30th November 2018

Our ref:
DAV001/VO/DC
Your ref:
18/01894/OUT

Outline planning application with all matters reserved for up to 25 dwellings with associated open space, parking and sustainable drainage - OS Parcel 4300, North of Shortlands And South of High Rock, Hook Norton Road, Sibford Ferris (Application No. 18/01894/OUT)

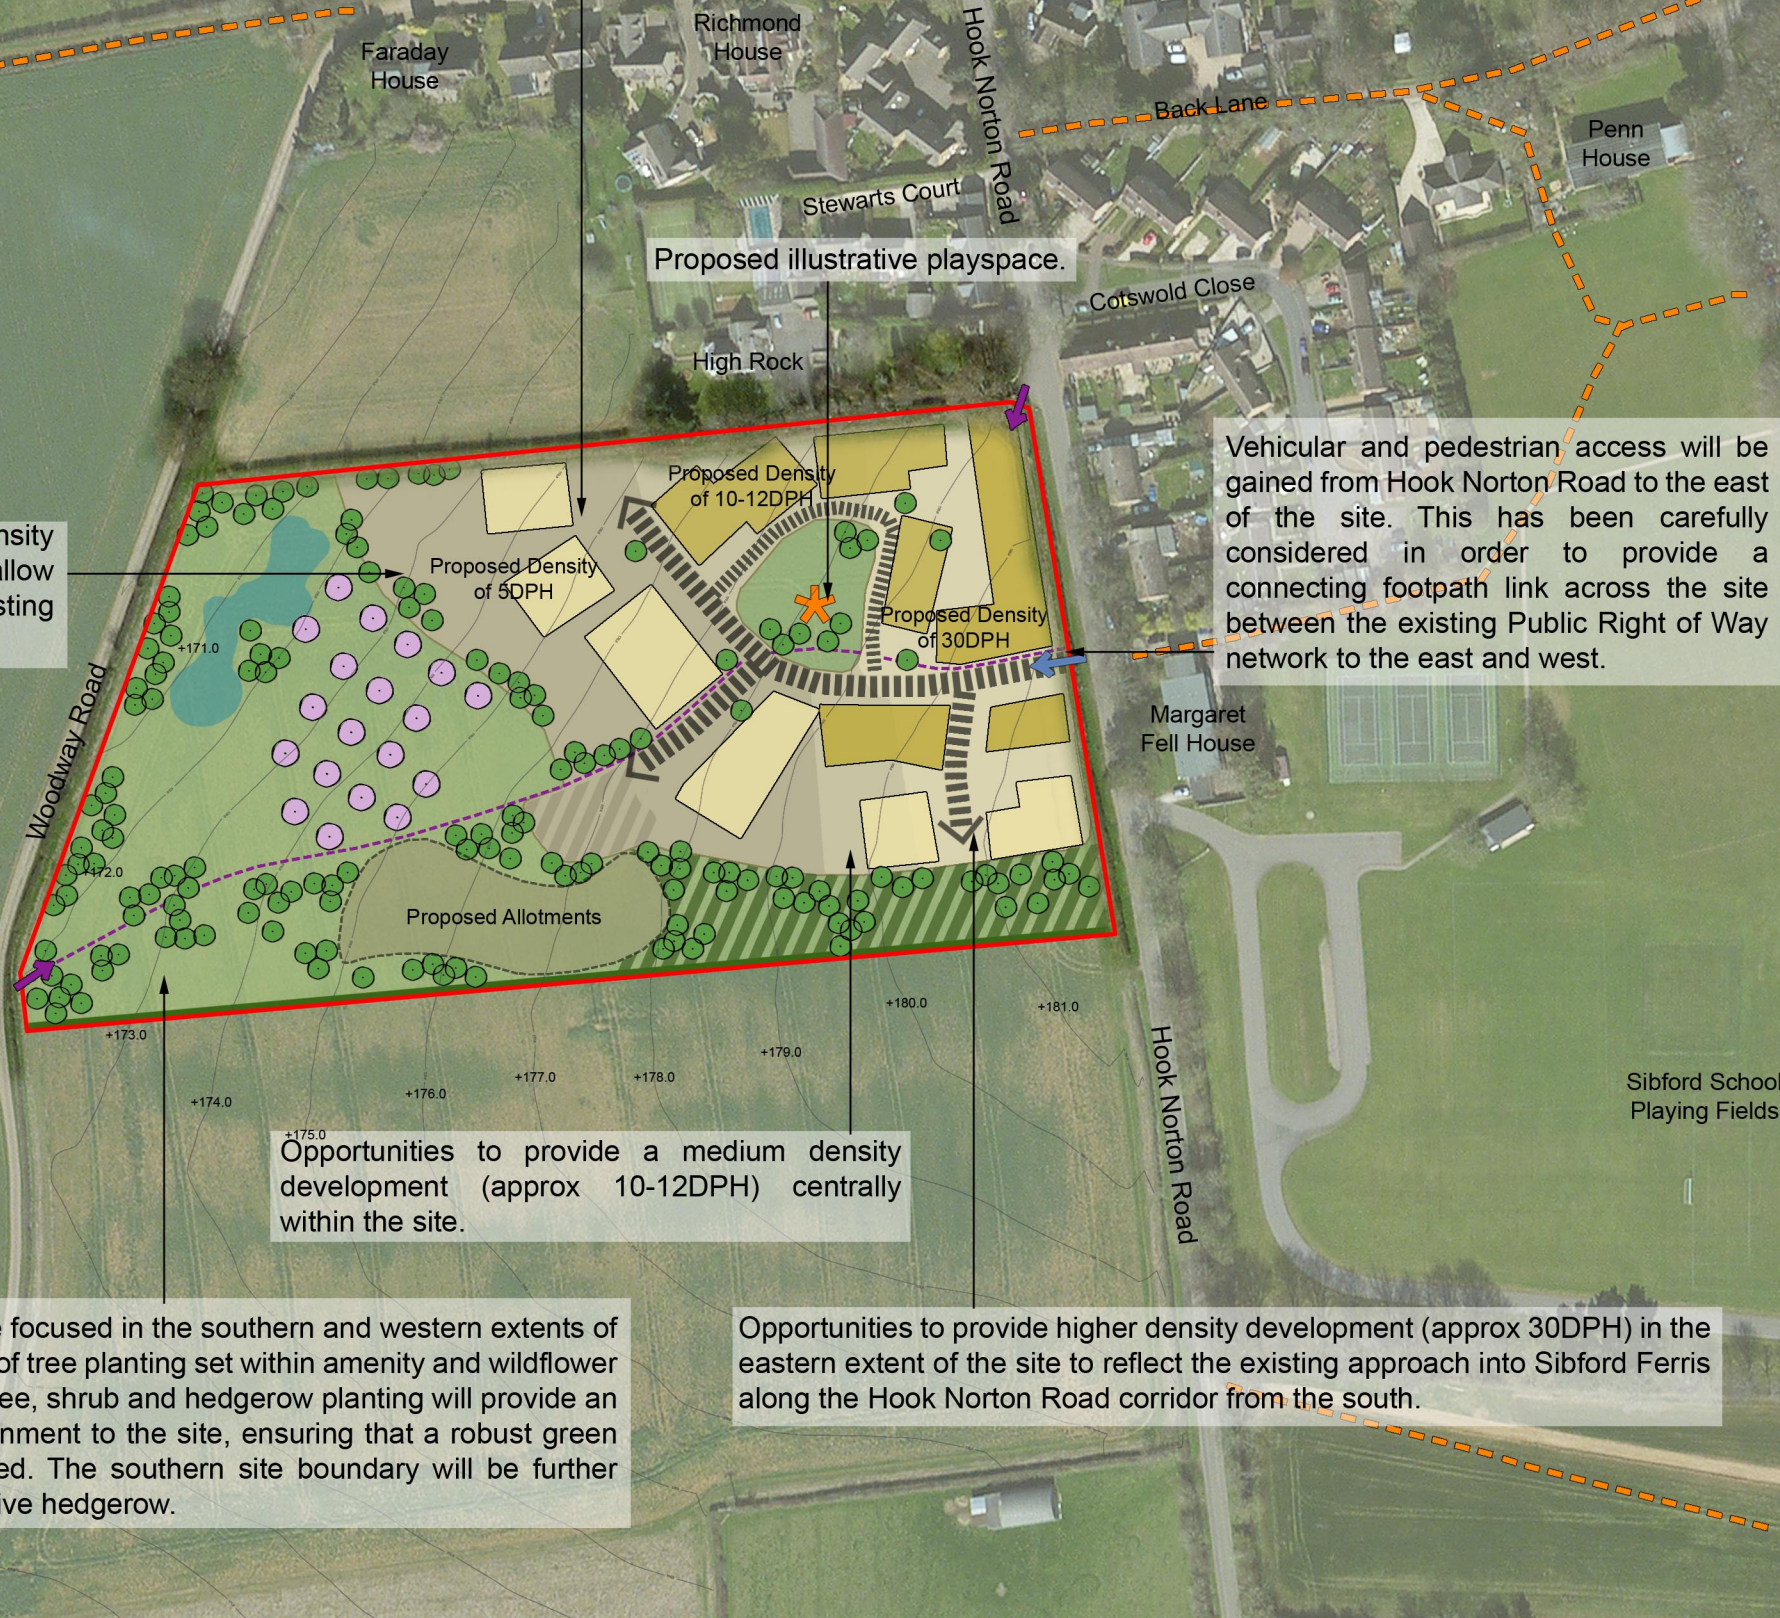
Although access proposals are shown on the Illustrative Masterplan, this is only for indicative purposes and therefore could be altered at reserved matters stage, if this application is approved in principle. The pedestrian footpath connectivity is positive but would not be a significant enough benefit to tip the balance of acceptability of the development proposal.

The access is sited only around 50m north of a change in the speed limit from the national speed limit of 60mph to 30mph and given the straight alignment and width of Hook Norton Road, the speed of northbound cars is likely to be higher than 30mph, meaning a longer sightline will be required. The only way to ascertain if this is necessary would be to perform an ATC speed survey to establish sightline requirements.

It is clear that this development – confirmed by the Illustrative Masterplan with its link to the adjacent, smaller field which may be 'suitable' for development - would provide the access necessary to bring this adjacent site forward. The proposal would not only have a significant impact on this part of the village in itself but is also more than likely to lead to further undesirable development, if approved, as not only physical access would be facilitated but a precedent for more development on adjoining land would be established, which would be very difficult for the Council to resist if it approved this scheme. It should also be noted that the site forms part of a much larger agricultural field, with no sub-division or boundaries, except a sparse hedgerow along Hook Norton Road. If the principle was established for development in this location, there is the risk that further development could ensue to the south towards Hook Norton.

In terms of actual size, the Illustrative Masterplan seems to demonstrate that the development would increase the size of Sibford Ferris by approximately 25% (in area terms) – a significant increase.
